Memo

Date: March 27, 2015

RE: CU-14-00004 McIntosh

Regarding the Conditional Use permit for McIntosh Party Barn, please attach the following comments:

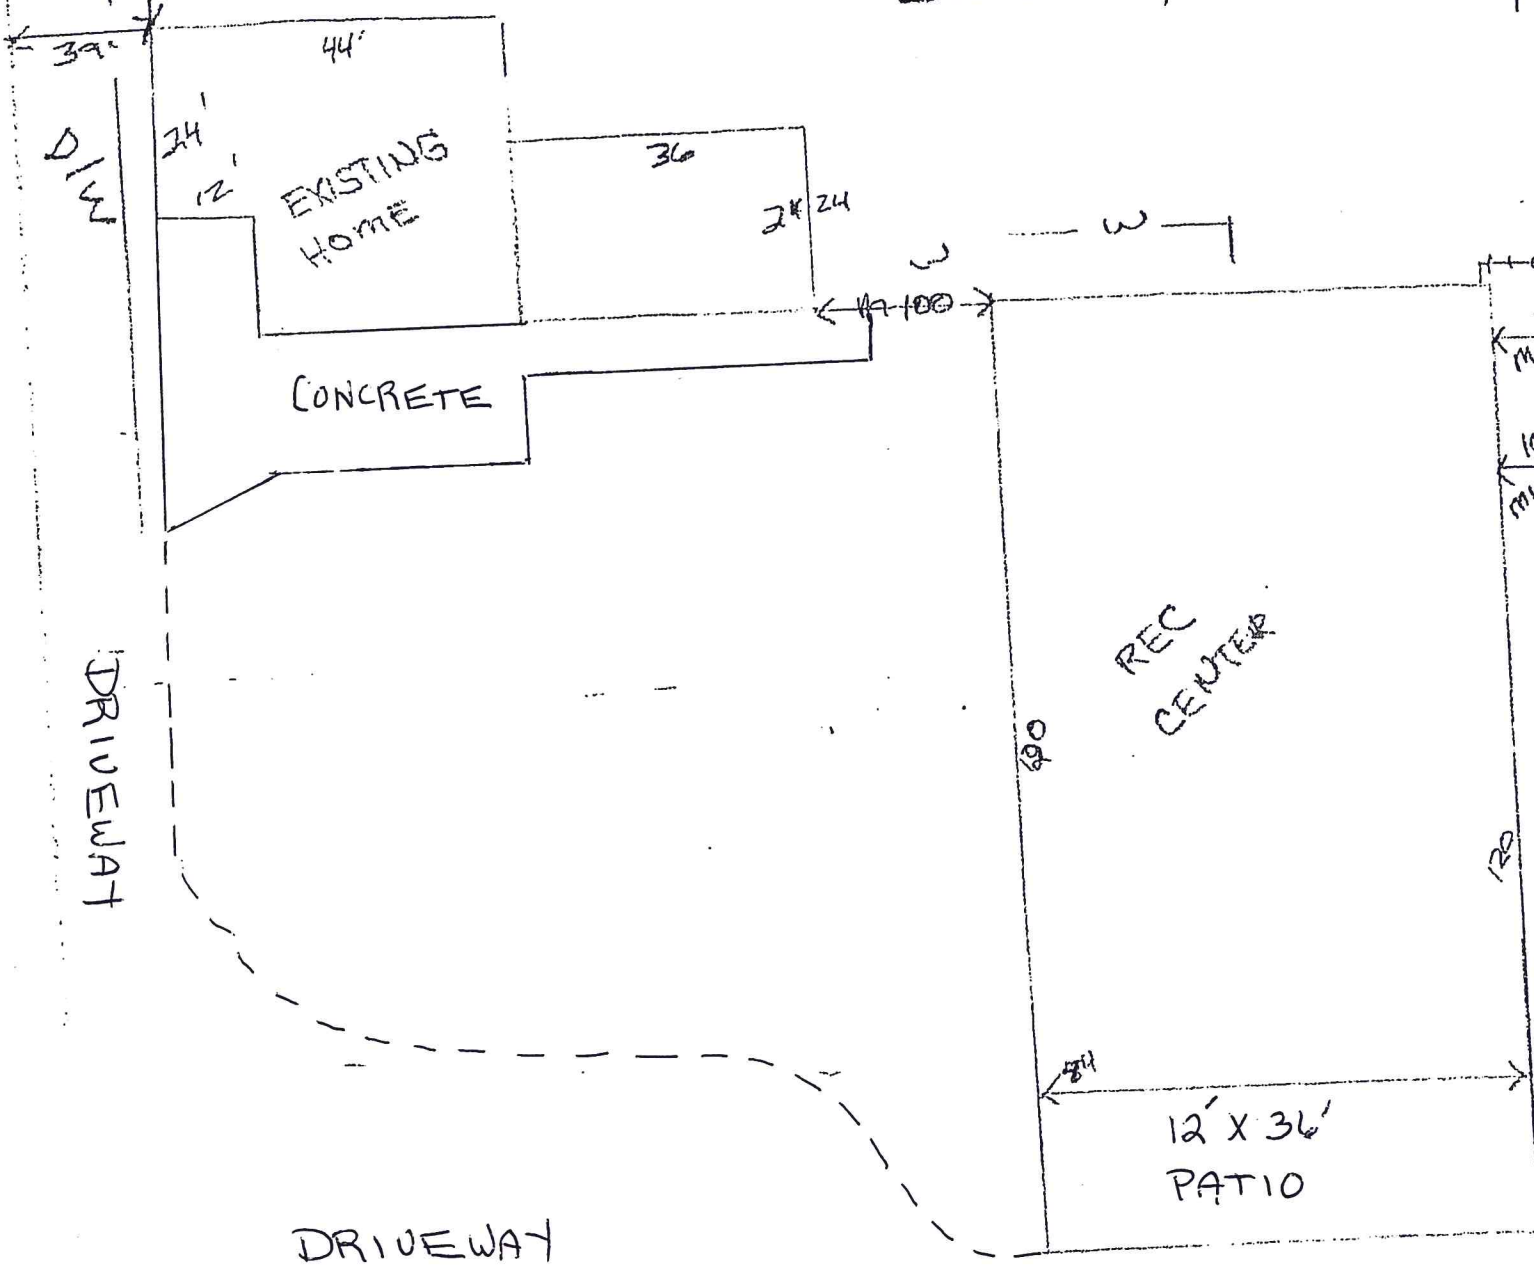
- The existing water system as a water source; requiring DOH approval for a Group A transient-non-community public water system.
- The first step in approval for a public water system is to schedule a well site inspection by contacting KCPHD at (509)962-7515.

Applicant has an onsite septic system capable of handling 480 gpd. Based on this capacity, the applicant must provide additional portable toilets and hand washing stations if the capacity is greater than 150 guests at the facility. This requirement holds true even with the additional proposed restroom facilities since the additional facilities will not add capacity to the onsite system.
